PAX19.324161_ WindFarm_Lemanaghan_Offaly_Heritage Council Submission

Re: Proposed development of 15 no. wind turbines, a permanent 220kV on-site substation, and associated infrastructure AT Lemanaghan and surrounding townlands, Co. Offaly.

Re: PAX19.324161- Proposed development of 15 no. wind turbines, a permanent 220kV on-site substation, and associated infrastructure AT Lemnaghan and surrounding townlands, Co. Offaly

Figure 1-3 Geographic Context of the Proposed Wind Farm Site in relation to the Lemanaghan Monastic Complex

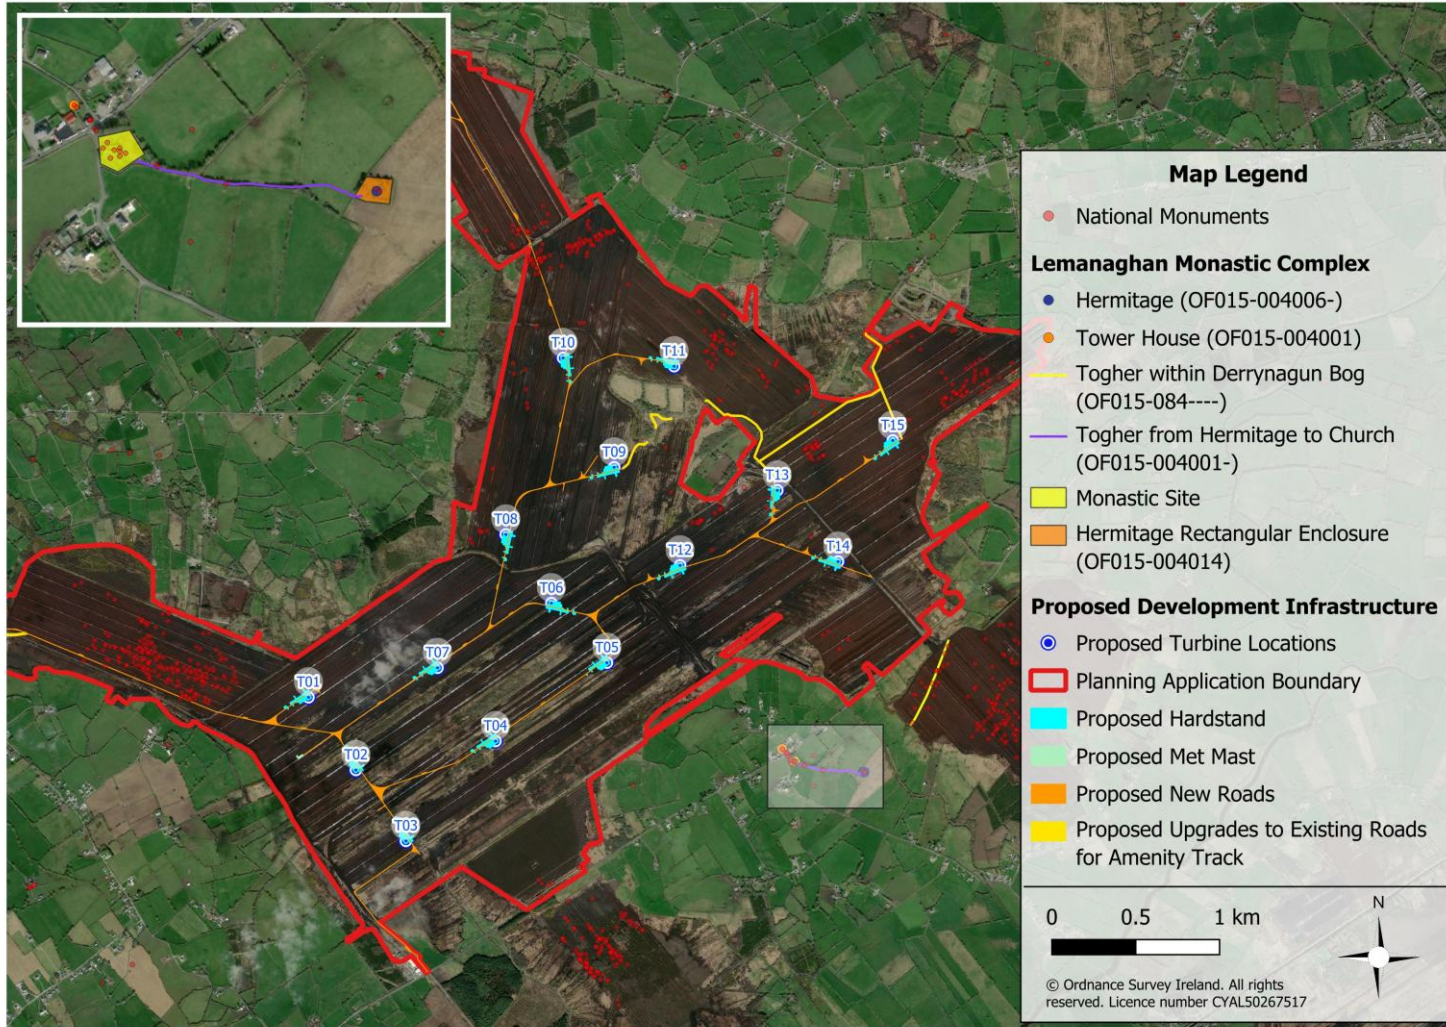
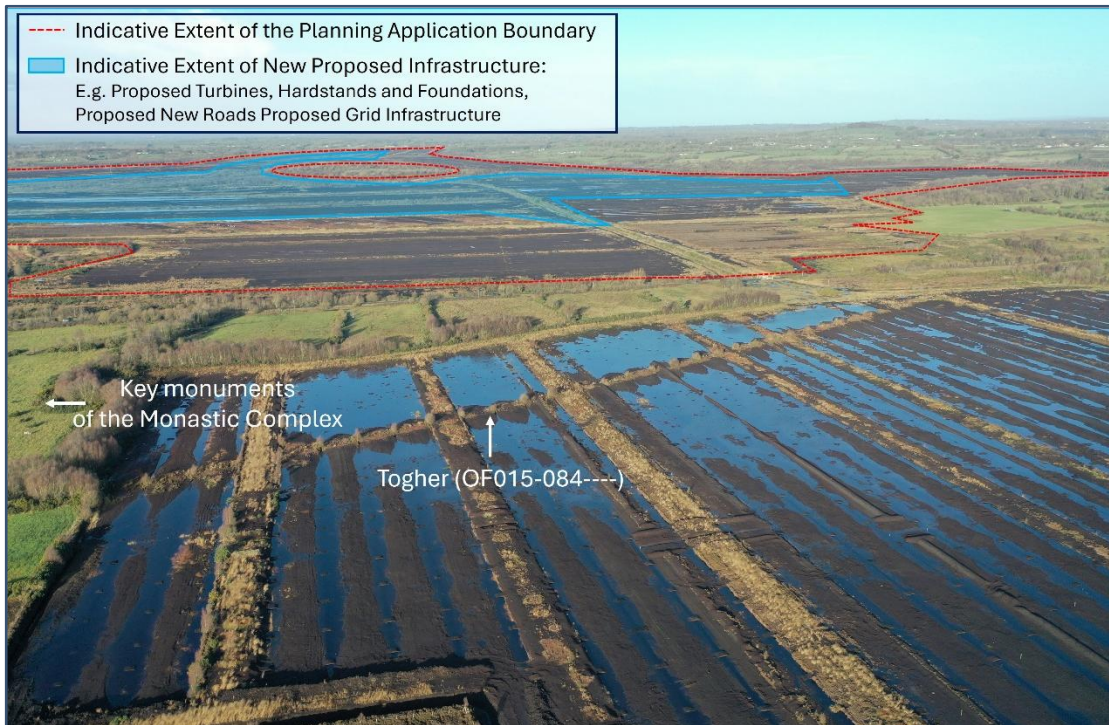
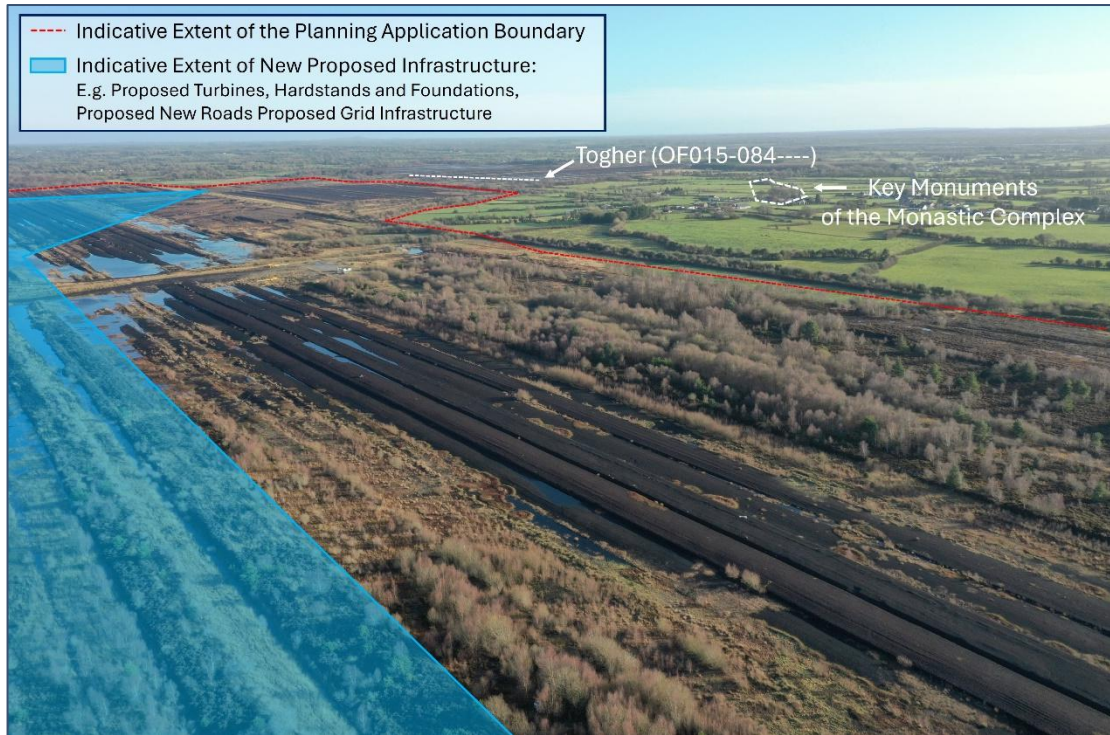
Having reviewed the Landscape and Visual Chapter and the associated views analysis and with due regard to the photomontages provided, which include representative viewpoints from the monastic complex, we believe that there is a medium to high magnitude of effect on a high sensitive cultural receptor. This should be deemed significant in EIA terms, and therefore mitigation is required. The current conclusion does not state this and is unacceptable in this regard.

Mitigation ought to be proposed for this specific impact. The removal, or relocation, of the most impactful of the turbines in terms of the visual setting of the Lemanaghan Monastic complex ought to be requested.

Fig. 1. Map showing the application area as outlined with a red line. SMRs are represented by blue dots.

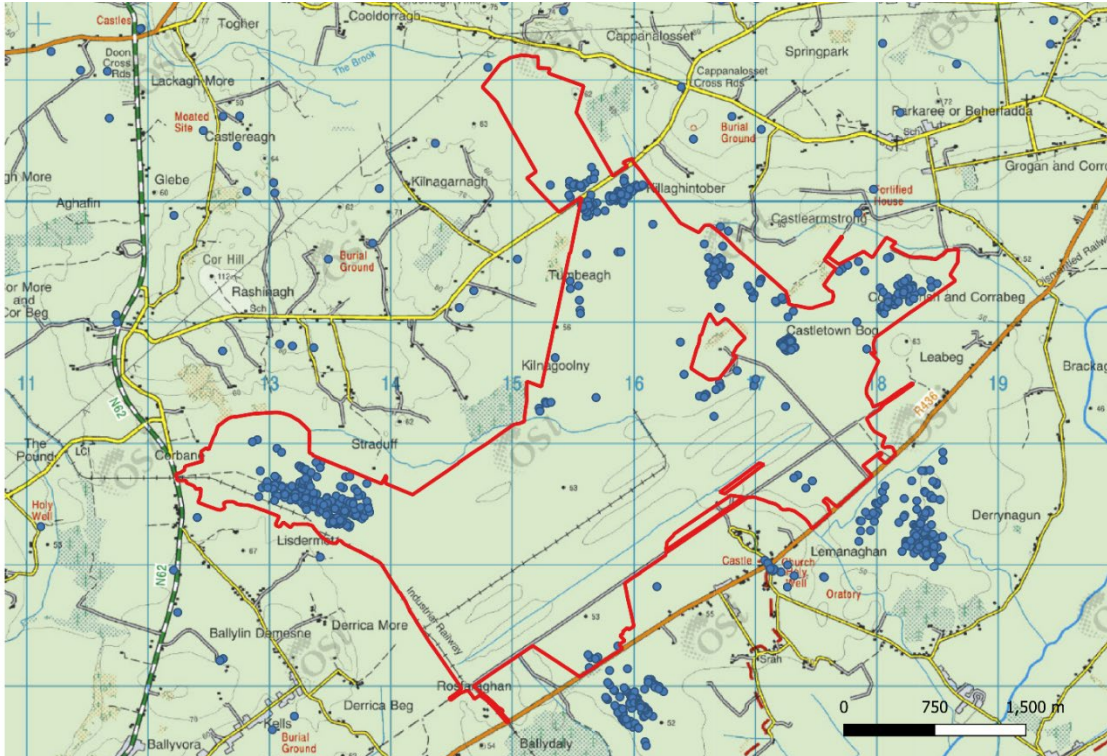
Finally, there is a curious absence of monuments in the central area of the bog around proposed turbines 1-8 and it is difficult to understand if this is due to survey and former peat harvesting considerations or whether this reflects a pattern in past activity.
